Application No. H09/1050/02/41

Description: Two storey house extension

Location: 8 Langwith Drive
Holbeach

Amendment: Revised brick detail

ELEVATIONS
SITE PLAN

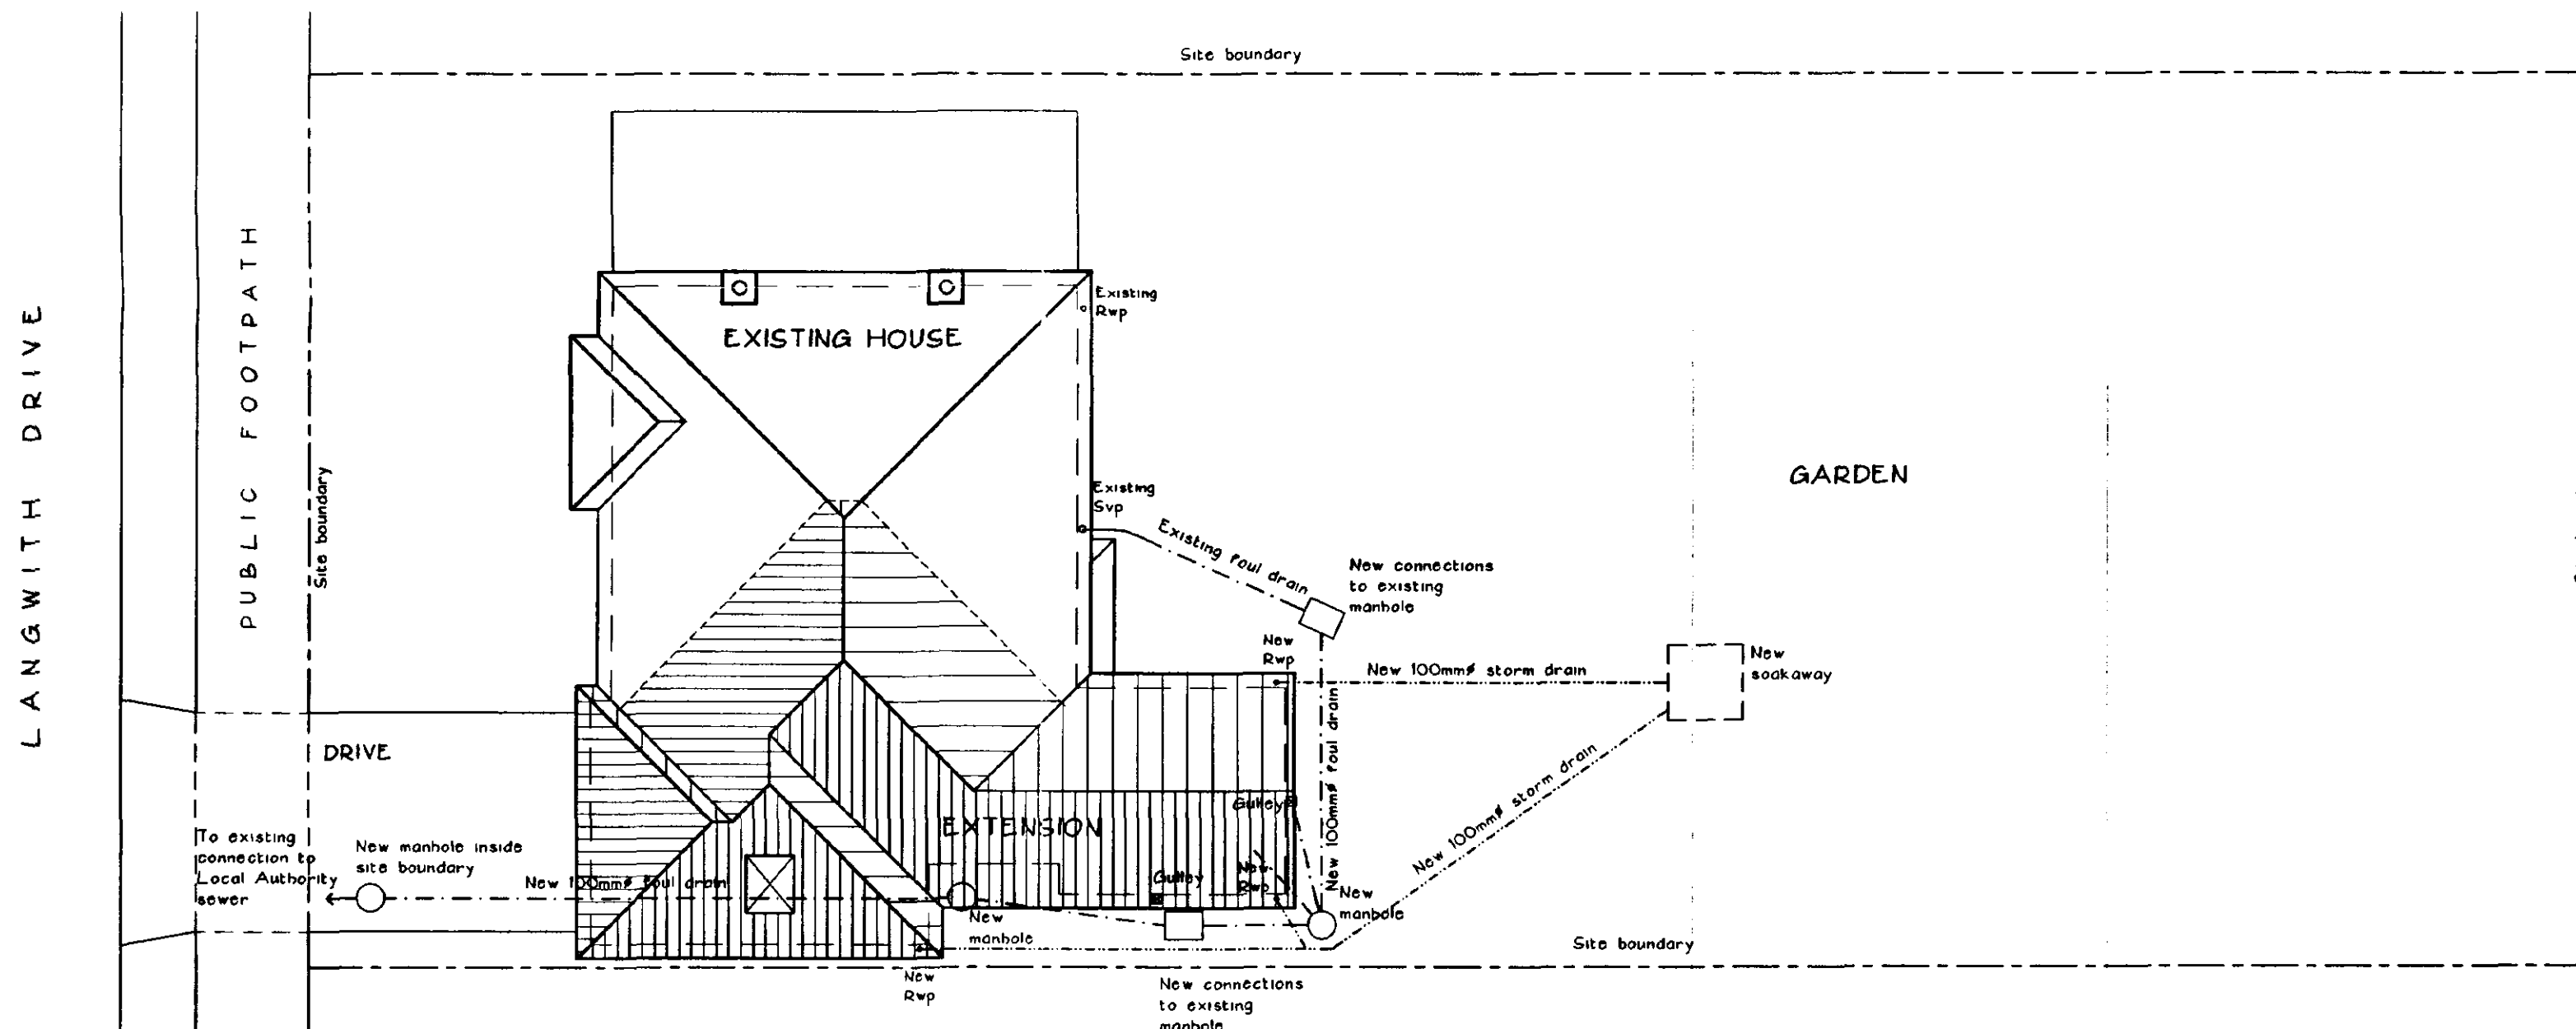
REVISE

Brick Detail

As per my telephone conversation with your office on the 19th December 2002, the specification for external face brickwork requires variation based on availability and cost.

The revision will see recycling of the existing face bricks for the front elevation and a contrasting red brick to all other elevations. A consequential benefit is that the proposed contrasting brick will be a superior grade brick. The "contrast" will only represent a minimal variation in colour and texture to avoid the more obvious "poor match" scenario.

The amended details submitted in respect of the above proposal have now been considered and there are no objections to the amendment being implemented to the extent described above.
